Advice on Environmental Impact Statement – State Significant Development

Proposal: Newington College Redevelopment (Concept and Stage 1) (SSD-78268465)

Major Project reference: SSD-78268465

Ground Floor Plan

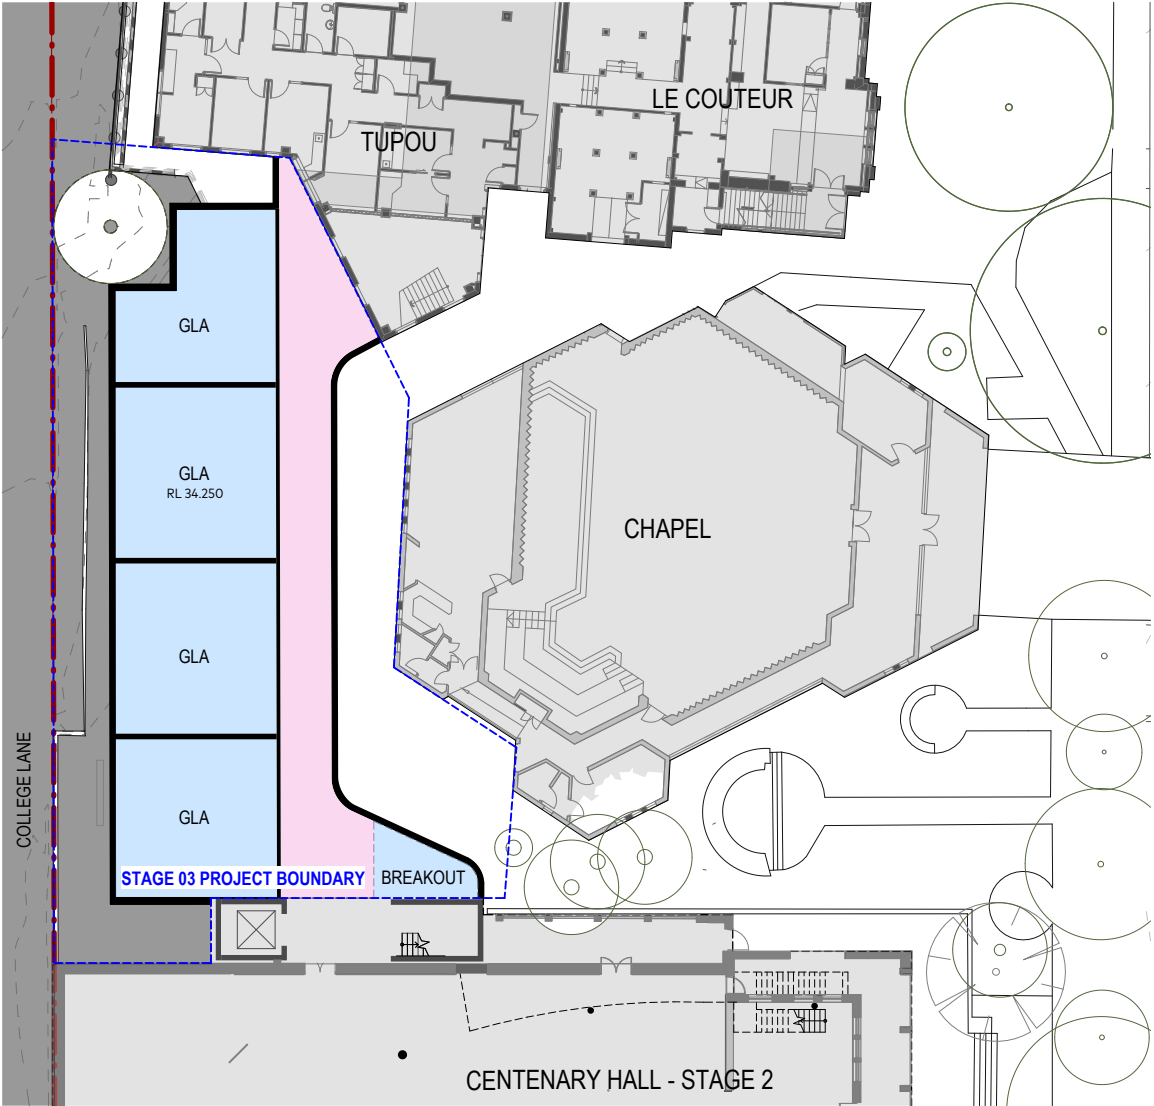
- Stage 1 works appear to be outside the SHR curtilage and would have negligible impact on the item.
- It is noted that the Concept plan (footprint - Stage 3) includes proposed building on College Lane (the College Lane Building). The northern end of this building extends across the heritage item. Any excavation works proposed as part of Stage 3 development must avoid direct/indirect impact on the SHR item, and the SOHI should address this matter adequately.
- Heritage NSW support the conclusions and recommendations of the HAIA (Section 8) and the excavation methodology outlined in the HARDEM. Recommended draft conditions of approval for environmental heritage (archaeology) are included in Attachment B.
